**RE: Harnett County Land Use Existing Tank Application # 17-5-41222
Mistywood Drive**

Based on the criteria set out in Title 15A, Subchapter 18A, of the North Carolina Administrative Code, Rules .1950, the evaluation indicated that the site is **UNSUITABLE** for the addition requested. Therefore, your request for an existing tank is **DENIED**. The site is denied based on the following:

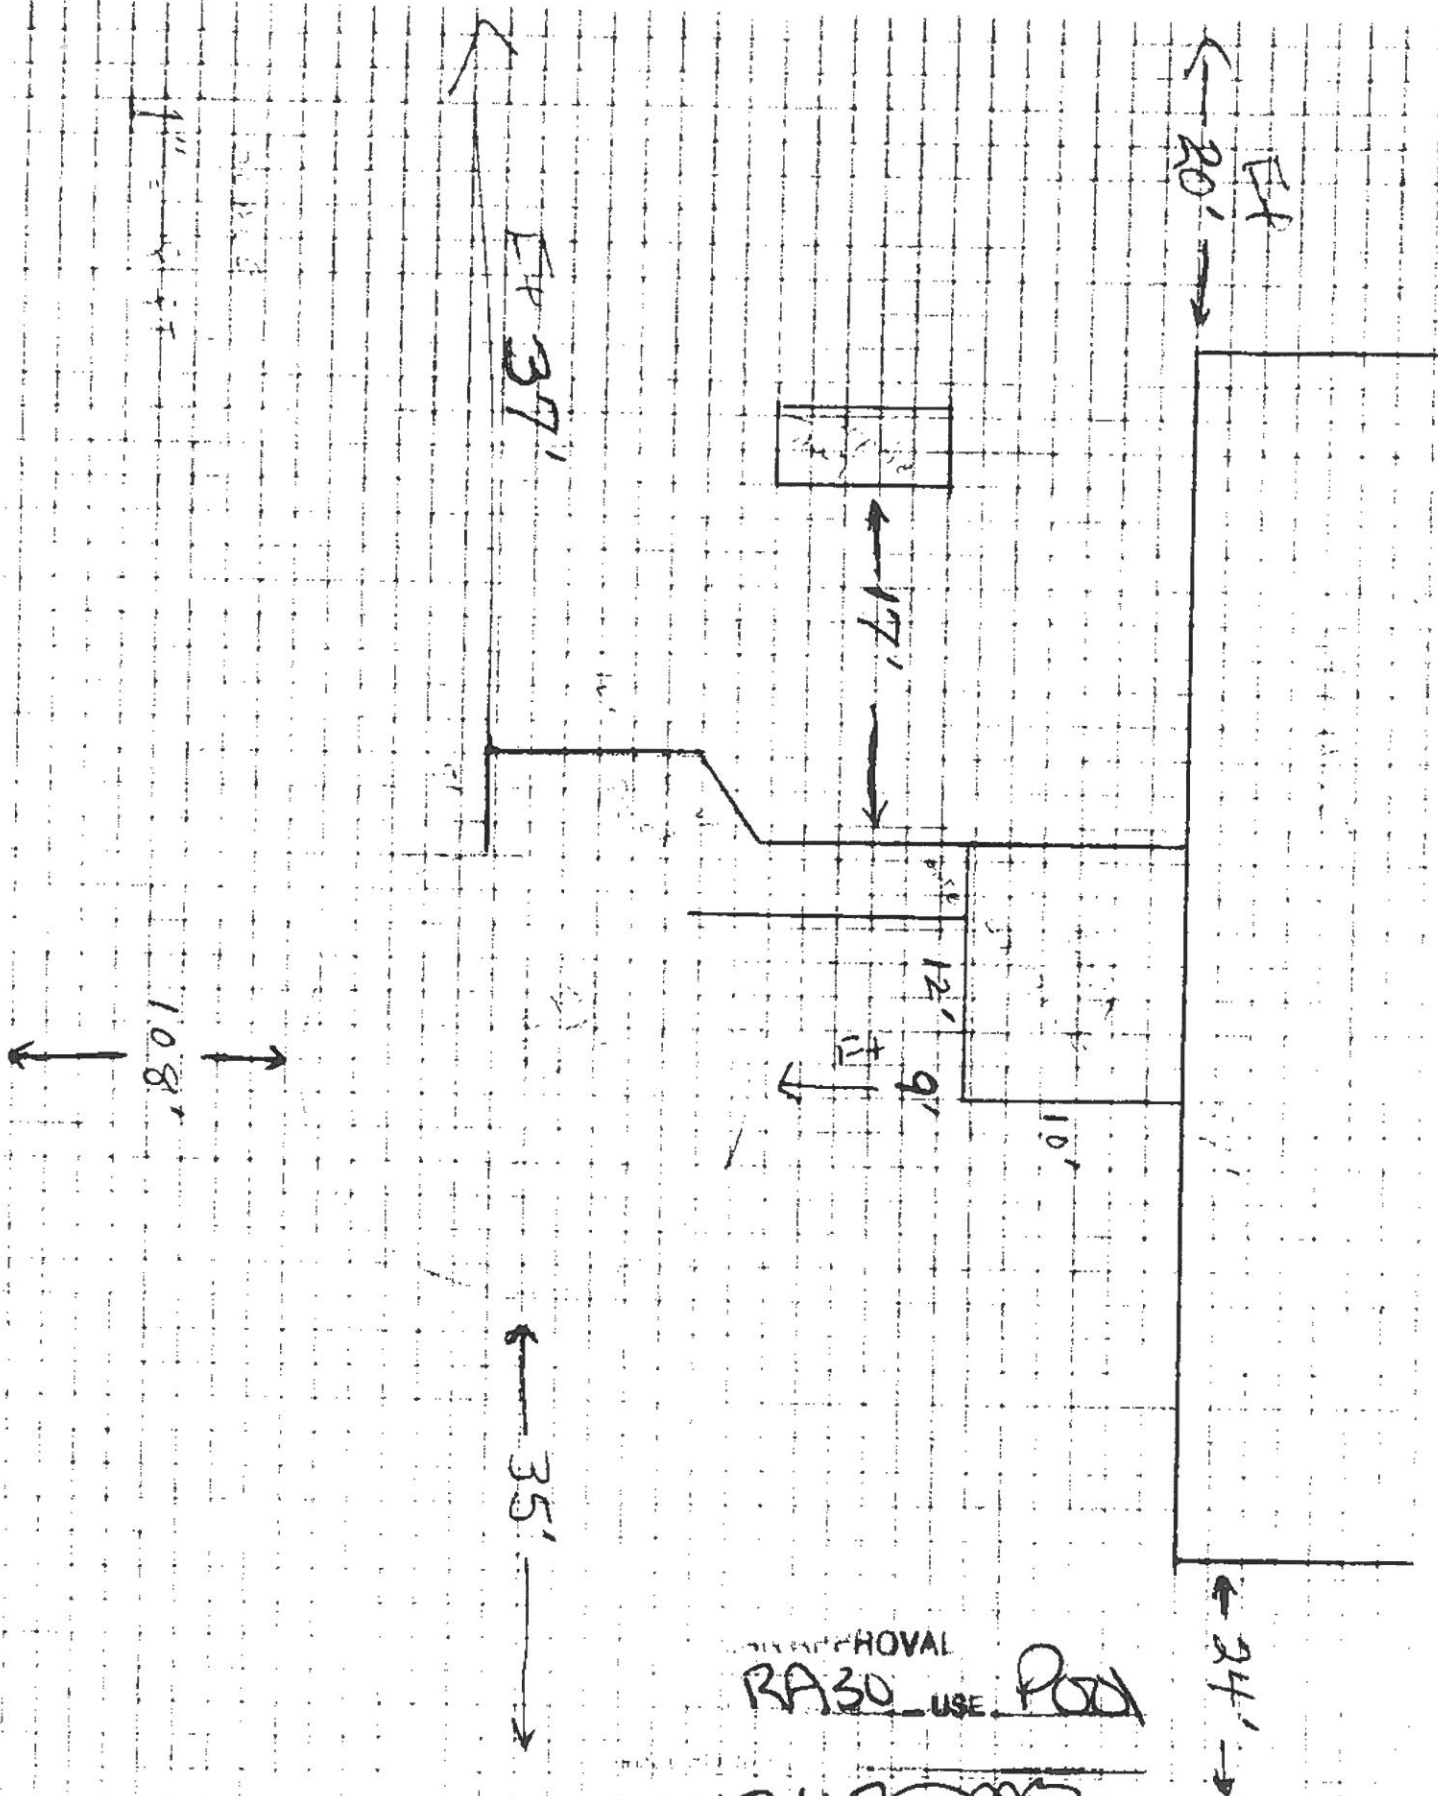
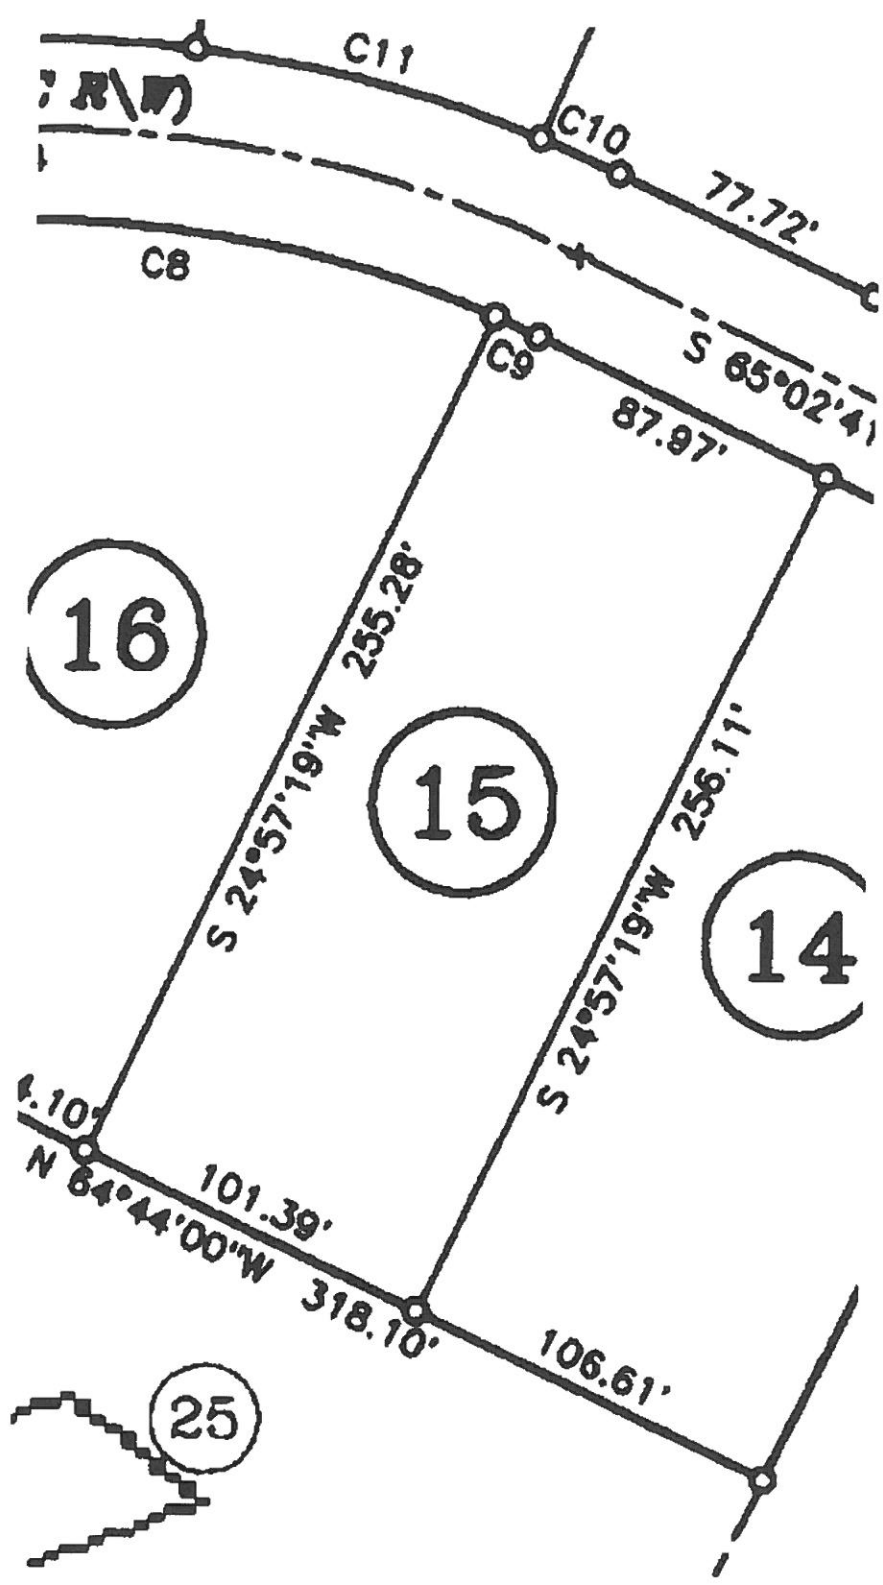
- 15A NCAC 18A.1950a {16} - Any swimming pool must be 15' from any part of septic system.**
- 15A NCAC 18.1945{b} - Each lot shall have original septic system plus repair area.**
- 15A NCAC 18A.1950 {10} - Any building to be 5' from septic tank and/or from drain line. Drain Lines appear to run under proposed garage locations.**
- 15A NCAC 18A.1950{c} - Nitrification fields and repair areas shall not be located under paved areas or areas subject to vehicular traffic.**
